WEST SUSSEX COUNTY COUNCIL CONSULTATION

TO:	Arun District Council FAO: Maria Tomalova
FROM:	WSCC - Highways Authority
DATE:	3 March 2021
LOCATION:	Land adjacent to 1 Cambridge Walk Bognor Regis PO21 5RL
SUBJECT:	AW/353/20/OUT Outline application with some matters reserved for 1 No. new dwelling.
DATE OF SITE VISIT:	n/a
RECOMMENDATION:	More Information
S106 CONTRIBUTION TOTAL:	n/a

Block Plan shows area bounded by: 491677.03, 99650.04 491767.03, 99740.04 (at a scale of 1:500), OSGridRef: SZ91729989. The representation of a road, track or path is no evidence of a right of way. The representation of features as lines is no evidence of a property boundary.

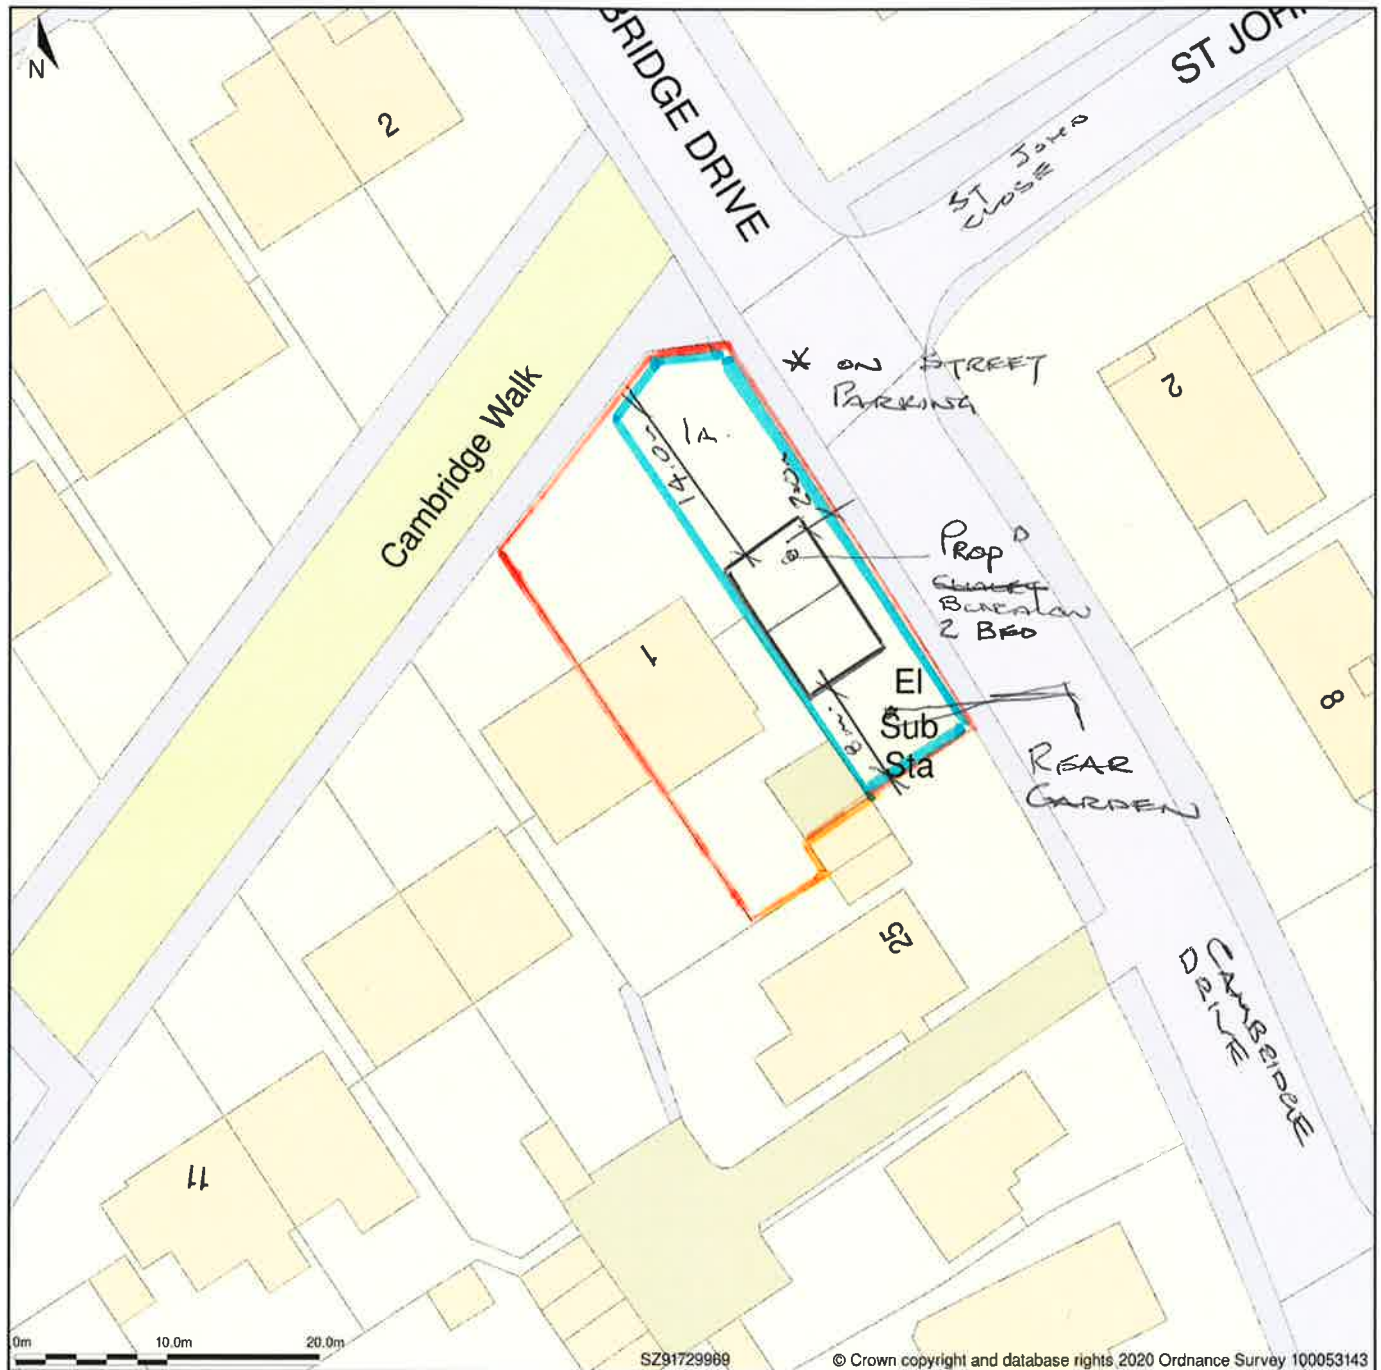
The applicant has submitted two location/block plans demonstrating the proposed site, however these contradict each other with regards to the proposed parking provision, one stating off-road parking and the other stating on-street parking. The applicant is requested to confirm the proposed parking arrangements as these details would be considered to fall within the 'Layout' of an Outline planning application.

If the applicant is intending to provide on-site parking for the proposed dwelling, a plan should be provided demonstrating the layout. The LPA is also advised to consider whether 'Access' would also be a relevant consideration at the Outline planning stage if parking is proposed.

Please request clarification from the applicant regarding the proposed parking provision and a revised plan, if necessary.
